**Notifications under Circular 01/2001, Circular 08/2009 &
T&CP (Development Management Procedure) Order 2010
THE OLD TANNERY, SHAWBRIDGE STREET, CLITHEROE, LANCASHIRE, BB7
1LY
Application No 3/2013/0766**

The current proposal is for the demolition and rebuilding of a single-storey rear lean-to and the repositioning of an internal ground floor staircase.

Ground Floor

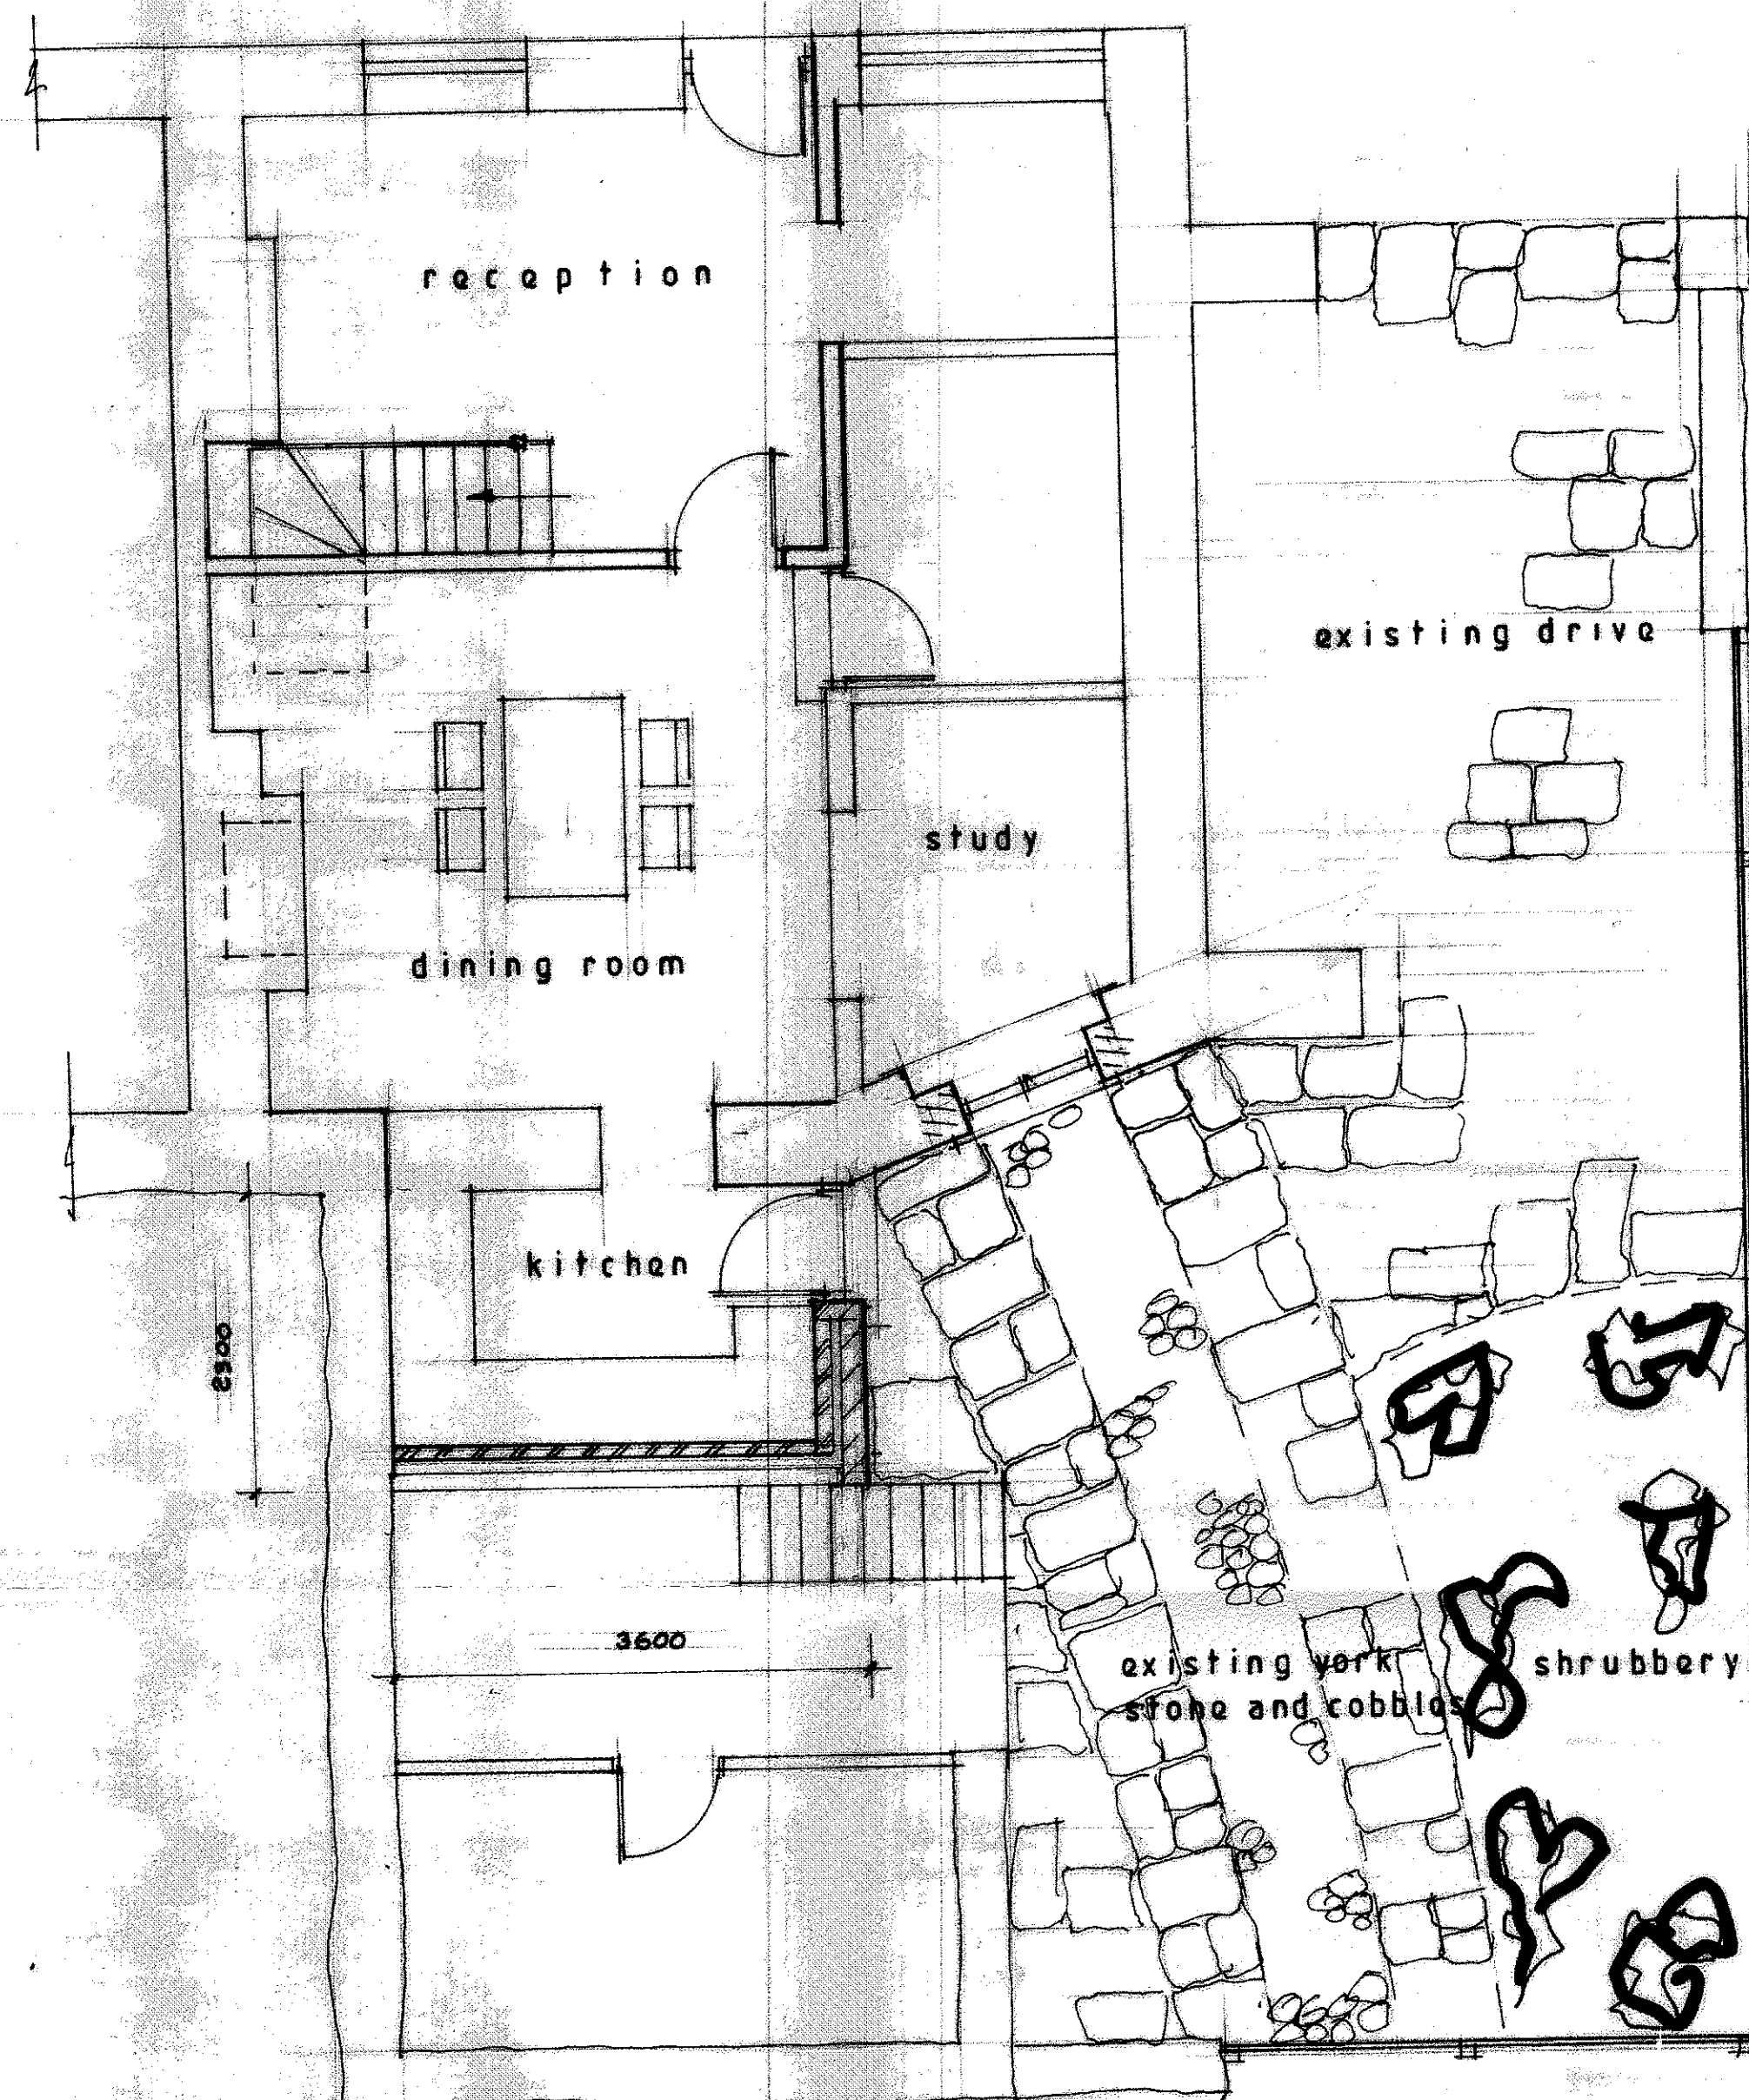
We welcome the proposals for the lean-to as this will enhance the setting of the Old Tannery. There is no information accompanying the application regarding the significance of the stair and the importance of its location within the building. The repositioning of the stair is effectively demolition and rebuild. If the staircase is original and in its original position the change would be difficult to support without clear and convincing justification. In determining applications, local planning authorities should require an applicant to describe the significance of any heritage assets affected, including any contribution made by their setting. The level of detail should be proportionate to the assets' importance and no more than is sufficient to understand the potential impact of the proposal on their significance (NPPF, para 128).

We recommend that the application should be approved if your conservation officer supports the detail and repositioning of the internal stair.
